From: Amanda Scholes on behalf of Planning.Responses
Sent: 09 August 2017 08:46
To: Planning Scanning
Subject: FW: BE/71/17/PL - Wickes, Bognor Drainage Scheme

Further Drainage Comments

From: Paul Cann
Sent: 08 August 2017 14:14
To: 'Tim Rainbird'; Simon Davis
Cc: Tom Woolner
Subject: RE: BE/71/17/PL - Wickes, Bognor Drainage Scheme

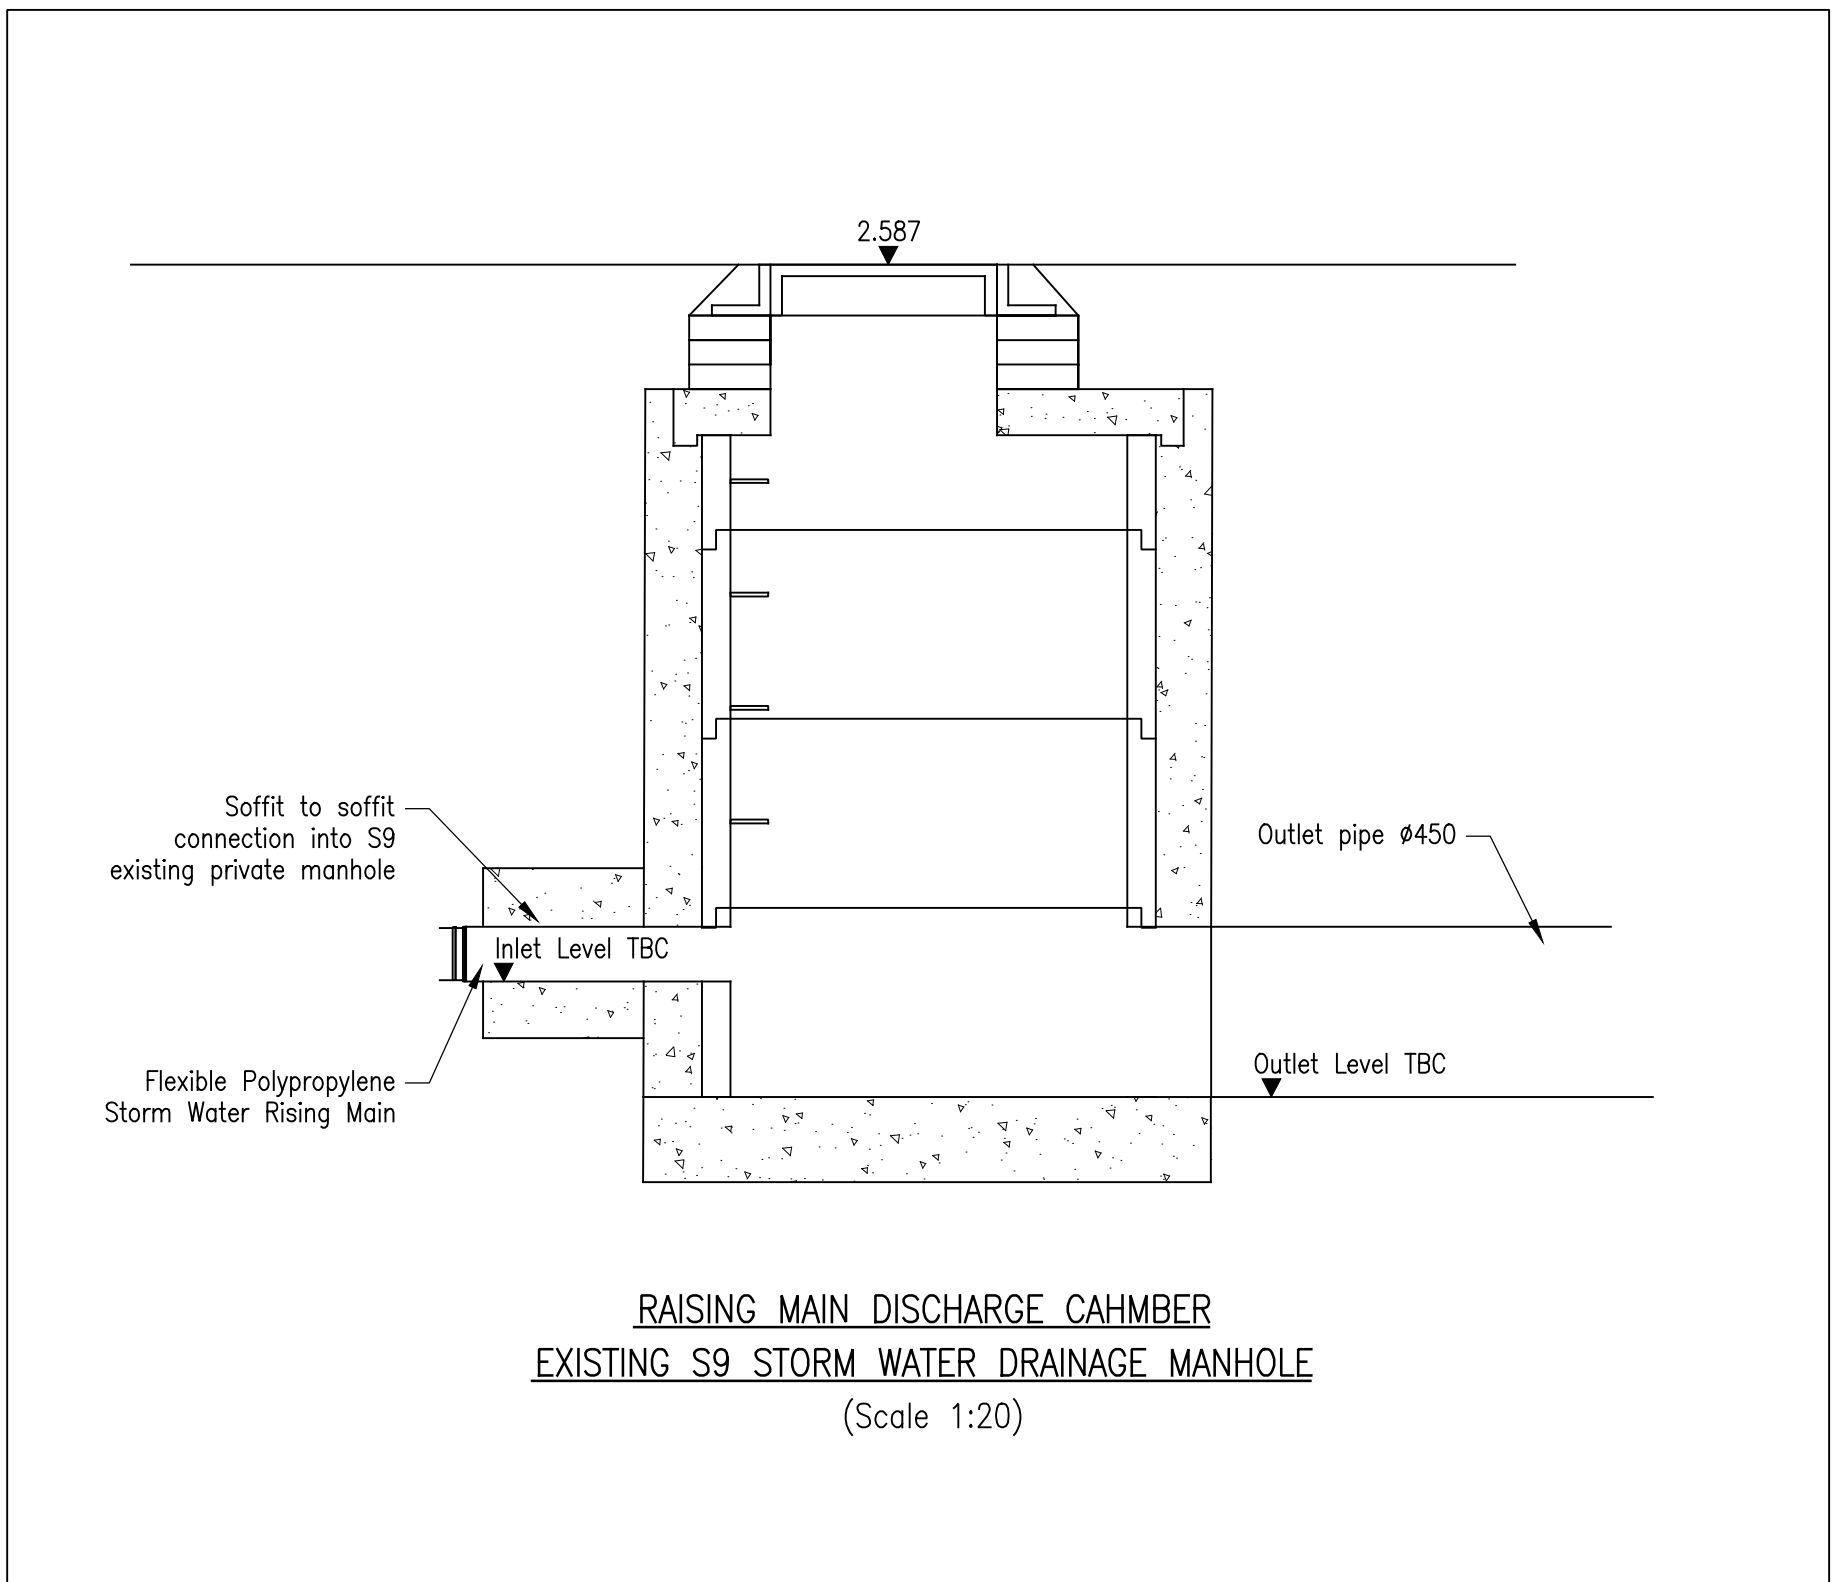
1. Full construction details of the pumping station and rising main. This will also need to include pipe bedding details, thrust block details and discharge chamber details.

5. It is important that the pipework configuration is considered carefully within the discharge chamber to ensure the smooth transition of flows. This will need to be detailed.

Typical details are on the attached drawing 15-112/500

The current discharge point is labelled as manhole S9 on the attached 'as built' drawing from the adjacent Sainsburys development. Specific details of this chamber is unknown although those of upstream chambers S10.1 and S10 are. Hence levels will be confirmed to the pump supplier when the contractor orders the pump.
